MoD SLA I Wattisham Airfield

Application No. DC/22/04231

S96a Non-Material Amendment No. 2 – Summary Report

S96a Non-Material Amendment No.2 – Summary Report

Title
BUILDING 1, GA
ELEVATIONS SHEET 3 OF
3-XX-G00400-XX

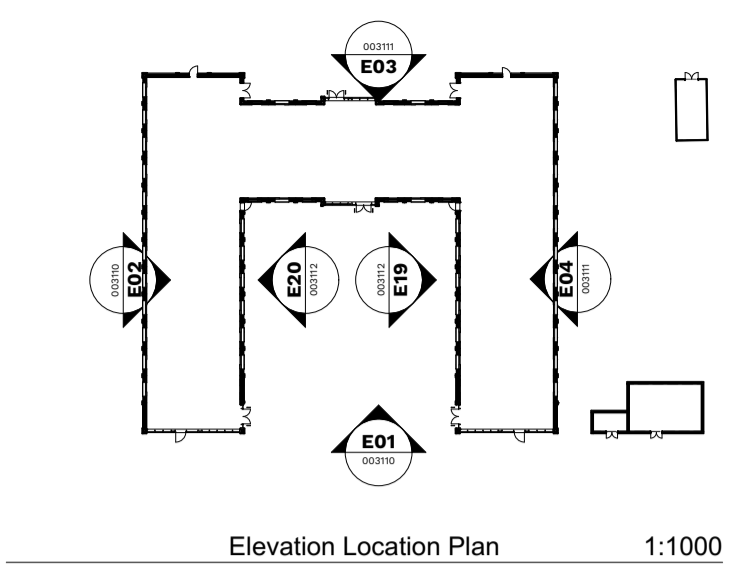
Reason for change : The required 6no. Air Source Heat Pump Units are proposed to be relocated on the roof of the SLA block. We are aware of the acoustic requirements and the technical details of the units have been supplied as below. The reasons for this change are listed below:

- Minimise visual impact -ASHP units are no longer overlooked by bedrooms and will be set-back behind an 1100mm high parapet.
- Reduced noise impact at roof level.
- No requirement for underground pipework so simpler coordination on site and installation
- No risk of underground pipework failure
- Reduced losses due to shorter pipework runs which will run vertically to the ground level plantrooms via service risers.
- The external area would be clear to locate the new substation and transformer – the location indicated on the site plan is the preferred location due to existing services constraints adjacent the other localised sub stations.

Title
SOFT LANDSCAPING PLAN-XX-G00400-XX

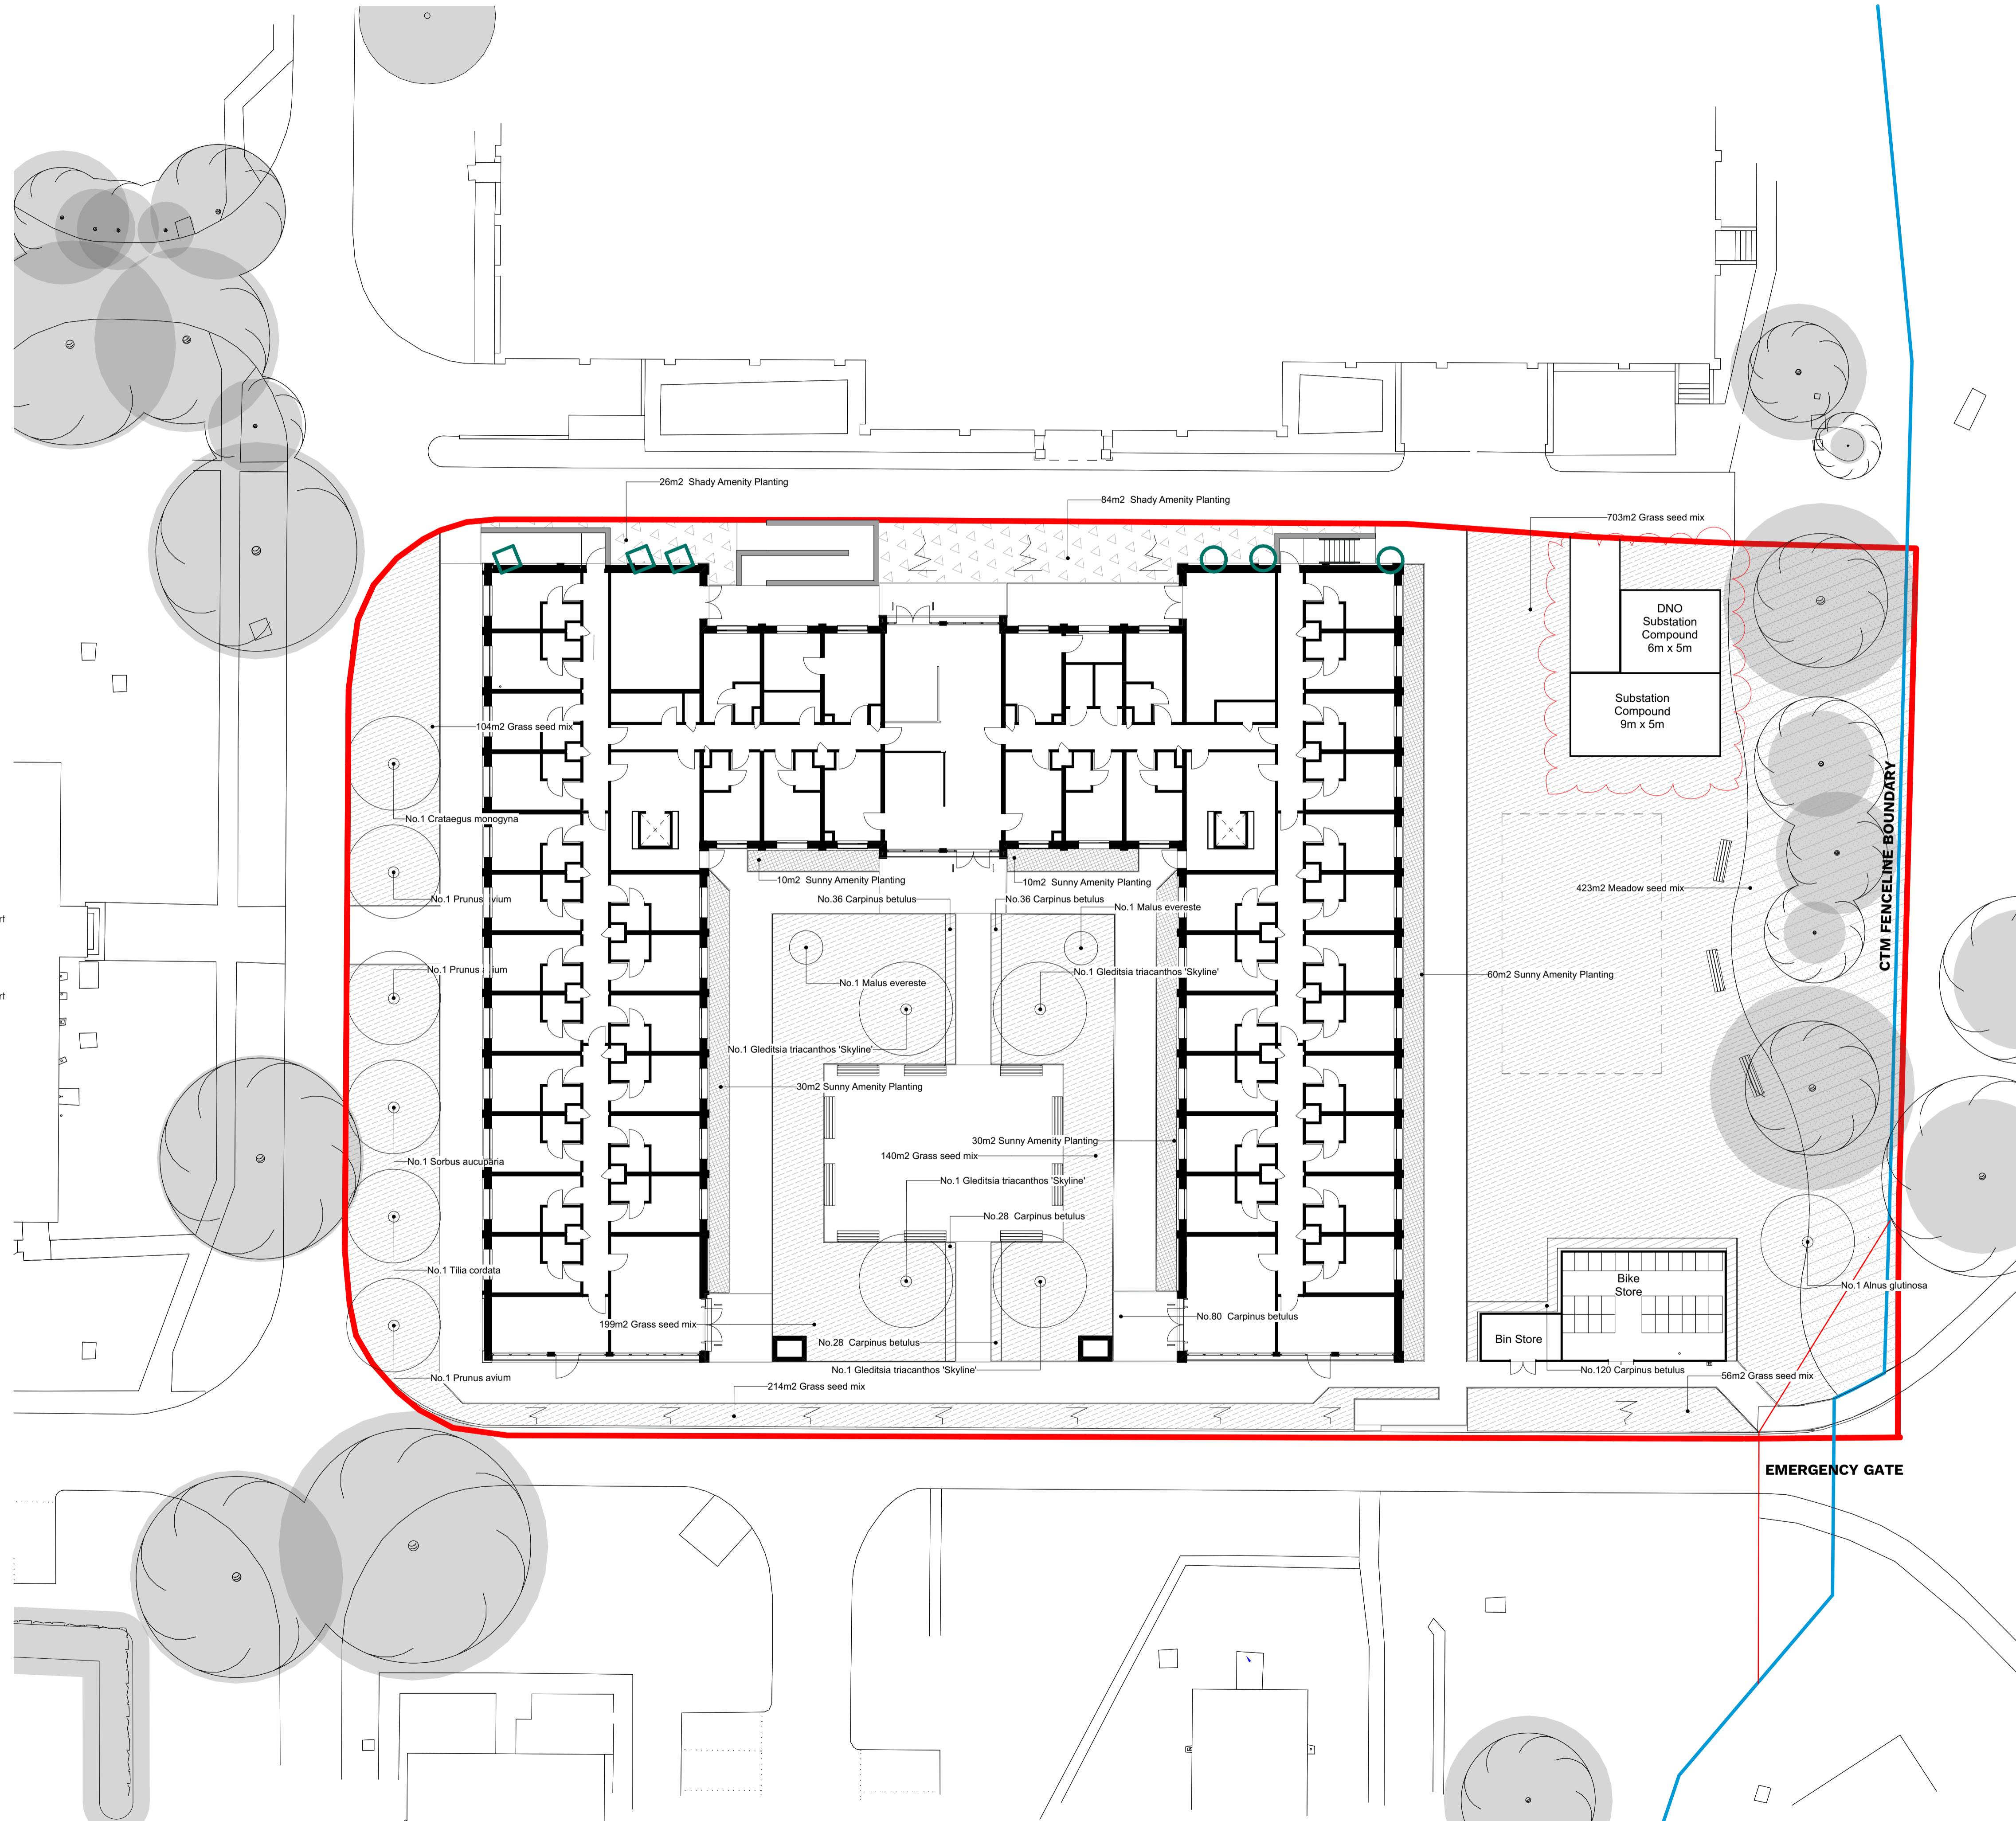
Reason for change : Minor external amendments to layout – to reflect repositioning of ASHP to roof and new substation requirement.

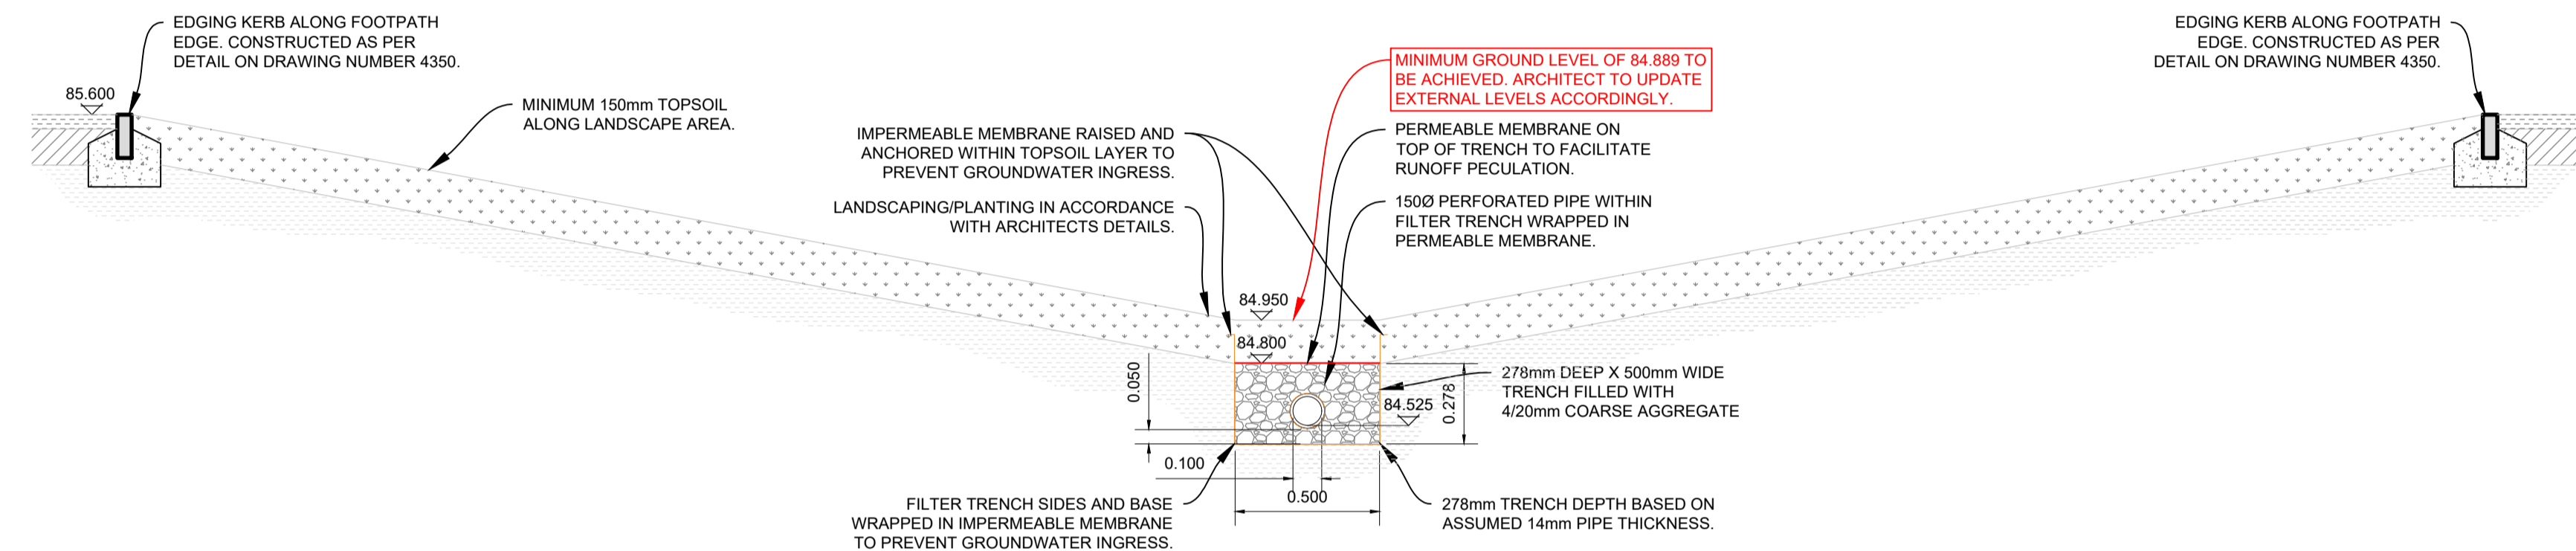
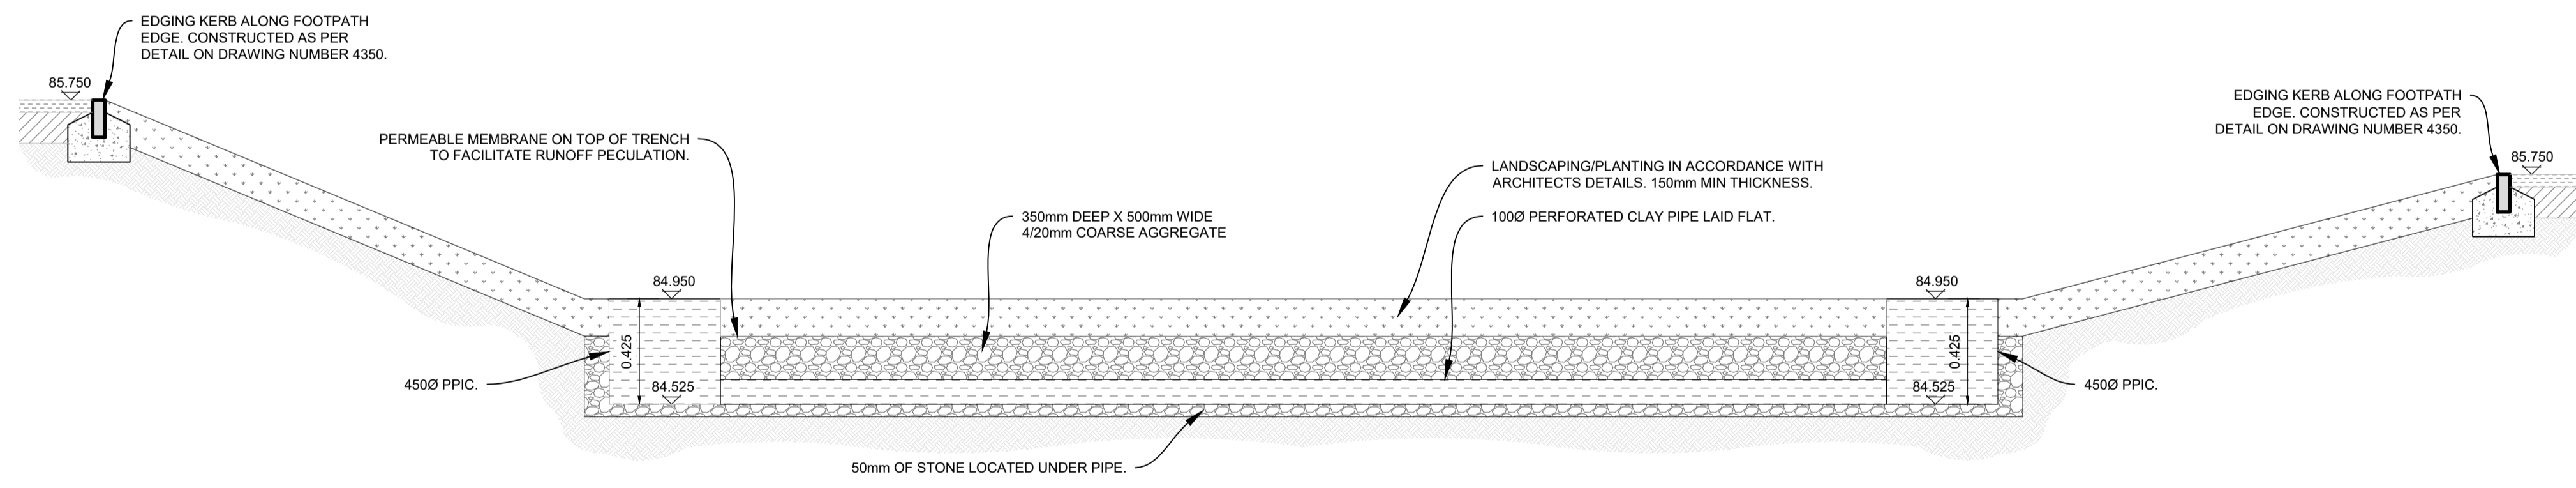
Reason for change : Variations to the drainage layout to suit unknown existing site services.
